APPEAL STATEMENT

Planning Inspectorate Reference:	APP/T2350/W/23/3329857
LPA Application Reference:	3/2023/0464
NGR:	SD 376116 434396

Against the decision of Ribble Valley Borough Council to impose an additional planning condition as part of an approval of planning permission for a domestic extension with balcony at 107 Whalley Road, Read BB12 7RP.

**WRITTEN REPRESENTATIONS SUBMITTED ON BEHALF OF
THE LOCAL PLANNING AUTHORITY**

SHEET:
PROPOSED ELEVATIONS 1

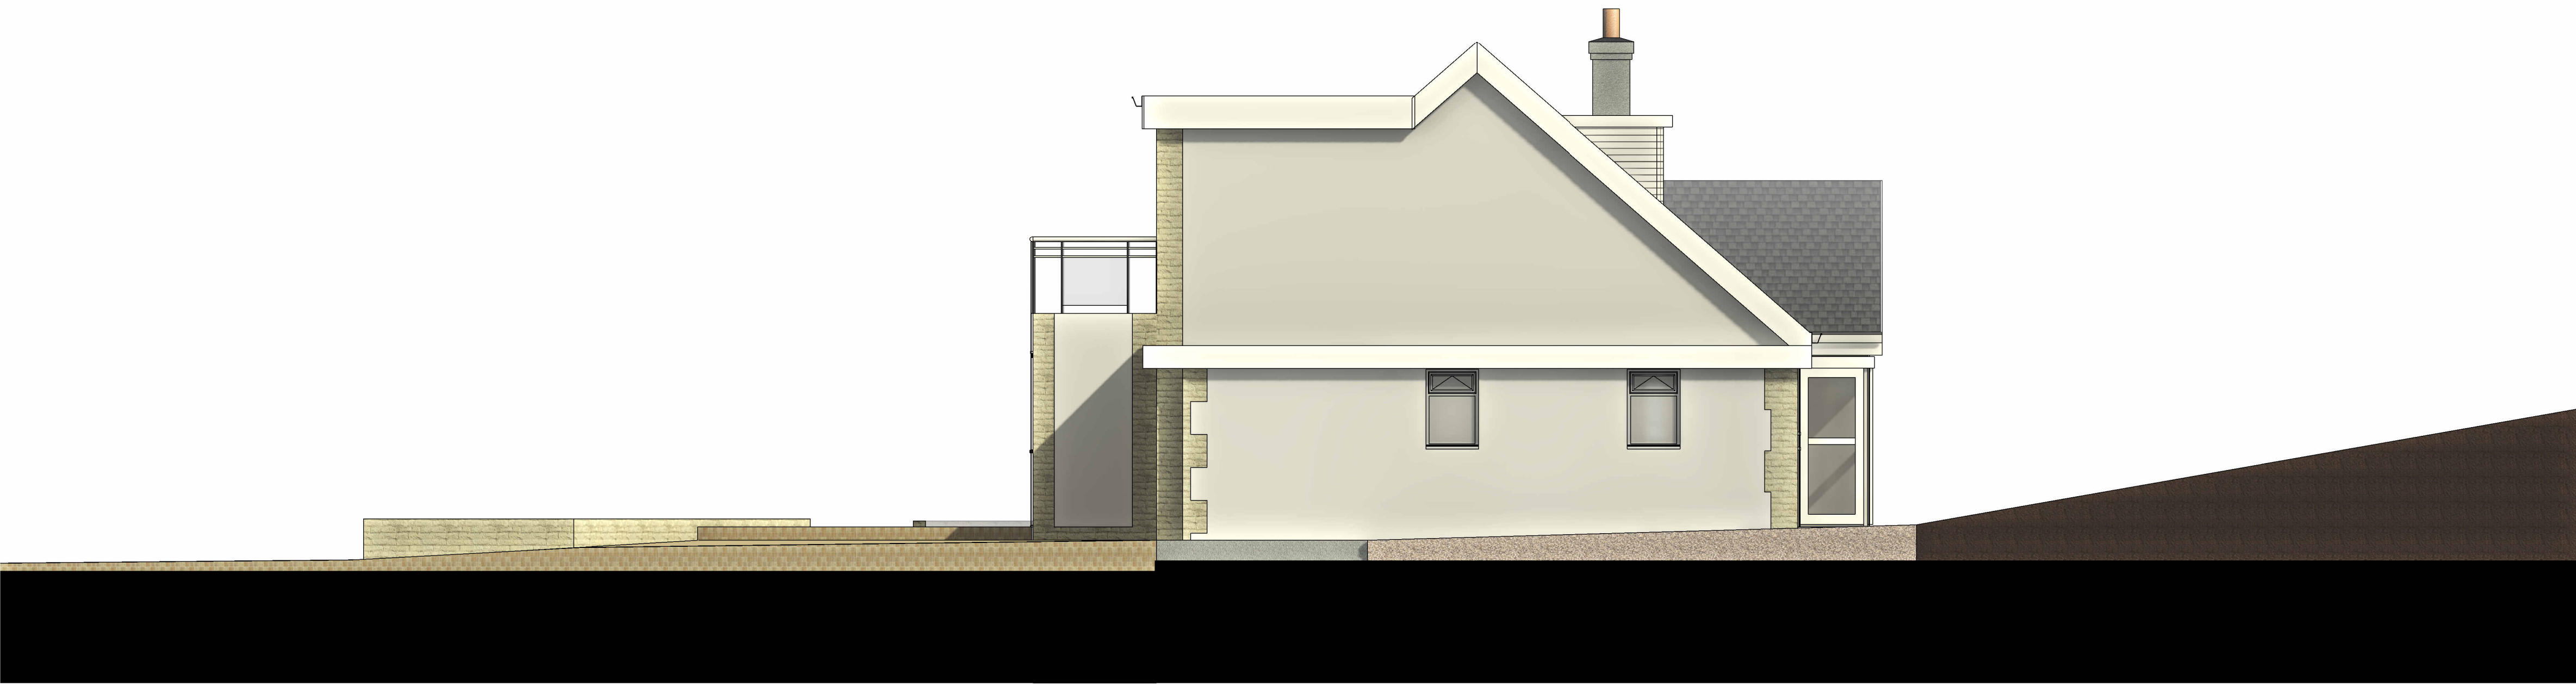
- 4.4 The balcony would be sited above the proposed extension and project 1.5m from the existing rear elevation of the application dwelling. The distance between the balcony and the neighbouring gardens is therefore less than the distance between the existing first-floor windows and neighbouring gardens. As a result, an increased level of overlooking is created. Moreover, the projection will allow for a person to be stood forward of the rear building line of the neighbouring properties which as a result creates potential for looking northwards towards the existing first floor windows on the Western gable of No.105 Whalley Road.

There is approximately 6.5m between the Eastern edge of the balcony and the western gable elevation of the neighbouring dwelling. Notwithstanding the existing single storey garage element this distance is minimal and would result in potential for direct overlooking into neighbouring windows at no. 105, in addition to the potential for overlooking of the private amenity space.

- 7.1 It is the Council's view that the proposed works would be only acceptable subject to solid privacy screens being erected to both the Eastern and Southern sides of the proposed balcony, in order for the scheme to provide adequate privacy and mitigate for any potential and perceived overlooking into both neighbouring windows and increased loss of privacy for their private amenity space.

Notwithstanding the submitted plans, the rear balcony hereby approved shall comprise two solid privacy screens at a minimum height of 1.8m on both the Eastern and Western sides which shall be constructed in materials to match the proposed single storey extension of buff brick and white render and shall be fully constructed prior to the first use of the balcony and shall thereafter be retained in perpetuity.
